Re Land at Summer Lane - P/58/15/OUT

The Hanbury plan to develop 90 houses on land at Summer Lane is laudable as Arun District Council is desperately short of new housing, like the rest of southeast England, but for the reasons set out below, the road is wholly inadequate to serve these new houses and the developer's proposed improvements to it do not overcome these limitations.

I therefore object to the application unless alternative access is proposed.

Figure 18 - Proposed Summer Lane/Pagham Road Junction

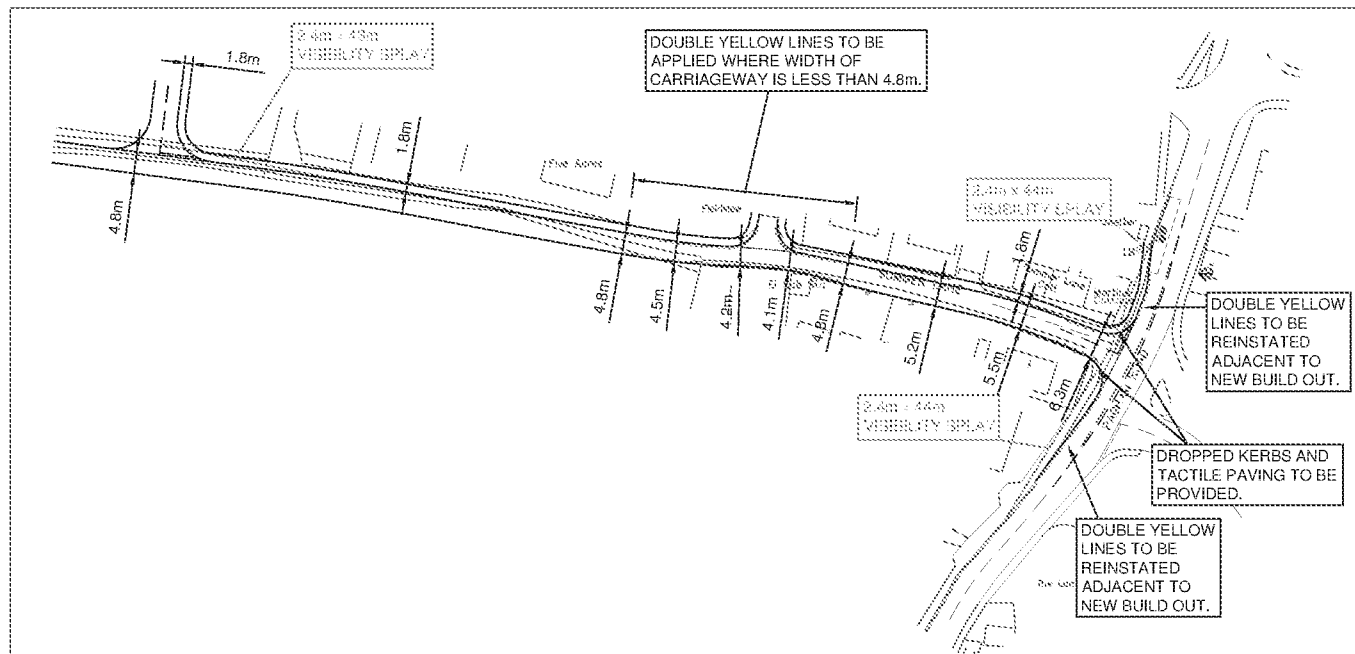
The narrowest section of the road is where the eastern access joins Summer Lane, at only 4.1m (as claimed in the proposal; 3.8m when a 300mm stand-off is provided). The developer proposes that this section should be subject to a parking restriction for 40m. However, the road from this point to the junction with Pagham Road is almost as narrow at 4.8m-5.5m (4.5m-5.2m allowing for a stand-off) and is currently used as parking along its northern side by the residents, narrowing it still further. As no parking restriction is proposed here, the entire parking demand of the existing houses bordering Summer Lane will be concentrated here and the effective width of this section of road will be much less than is claimed.

Furthermore, even to achieve its proposed road width of 4.1m (at the narrowest point), the Hanbury proposal relies on removing the footway from the south side of Summer Lane and relocating it to the north, reducing the stand-off from properties to the south, for a 40m stretch of Summer Lane either side of the first access to the Hanbury site, to 0mm.

In order to provide adequate visibility for vehicles emerging from Summer Lane, the developer proposes revisions to the junction with Pagham Road, building out the kerb and narrowing Pagham Road. These revisions in turn create a hazard to traffic on Pagham Road, according to the Road Safety Audit, which would require parking restrictions on Pagham Road.

The Road Safety Audit also notes that the removal of the footway on the southern side of Summer Lane reduces the inter-visibility of northbound pedestrians on Pagham Road and traffic exiting Summer Lane and thus creates a hazard to pedestrians. However, the recommendation of the Road Safety Audit and the SPC to retain a footway around the southern side of the junction, would reduce the width of the junction from 6.3m to 4.5m, assuming a footway of 1.8m minimum specification. Thus, given the its constraints, the junction cannot meet the required standards for pedestrian safety and minimum traffic clearance dimensions at the same time. One or other hazard will always be present.
